10 April 2024

Your Ref: SSD-62802207

**Comments on Hills Showground Precinct East
3 Andalusian Way, Castle Hill (adjacent Hills Showground Metro Station)**

DEVELOPMENT ASSESSMENT PRE-LODGEMENT MEETING NOTES 32/2024/PRE – 1 December 2023

Basement Level -1

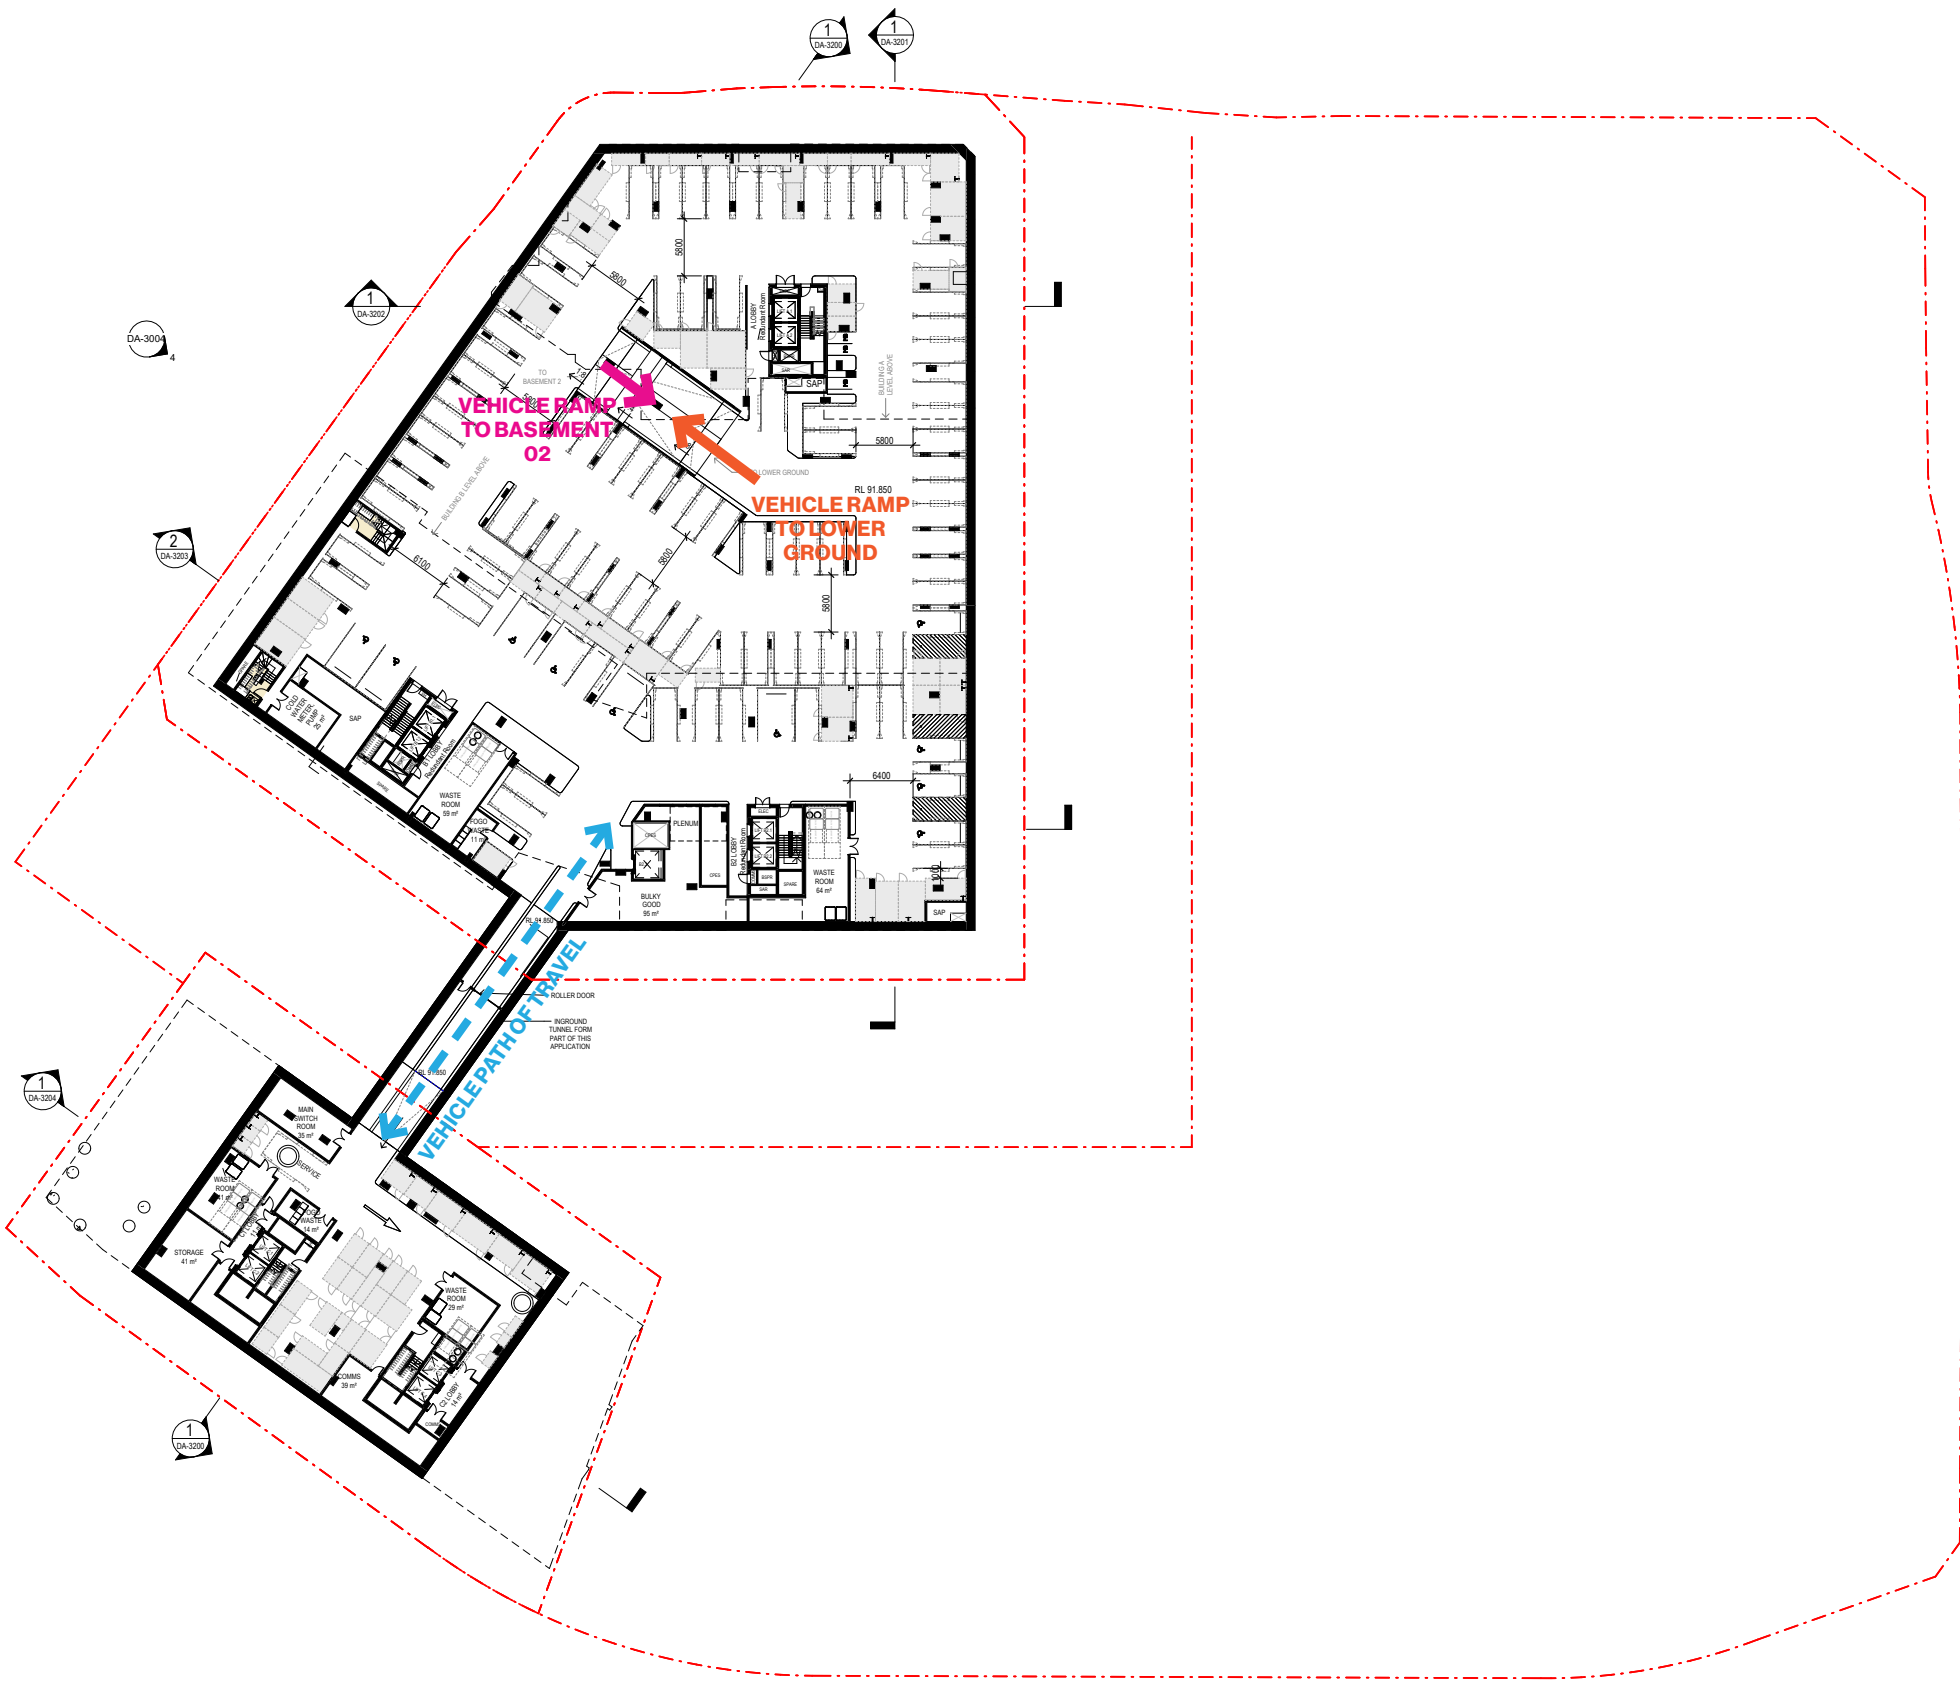
- A turning bay will need to be provided within the basement visitors parking.
- Sight distance shall comply with figures 3.2 and 3.3 of AS2890.1:2004.
- Stopping Sight Distance (SSD) and Safe Intersection Stopping Distance (SISD) based on Austroads Guide to Road Design Part 4A shall be considered for longest vehicle accessing the basements and the road intersection, and longest vehicle accessing the basements with the bend of the future road.

View from Precinct East Park

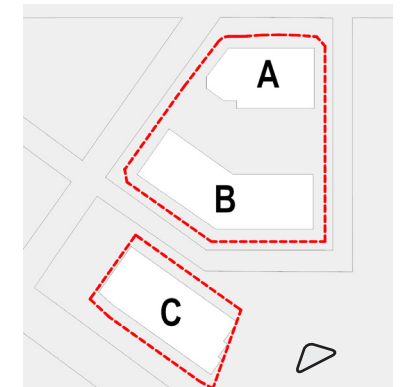
Whilst the local park solar plan identifies 65% of sunlight for 2 hours during the winter solstice, we are still concerned this is quite minimal for a site that will consist of plantings such as trees, shrubs and turf, and the ability to keep this vegetation thriving during this period of the year with anticipated high use. The grassed area appears to be in the north of the park, likely to receive the least amount of sunlight.
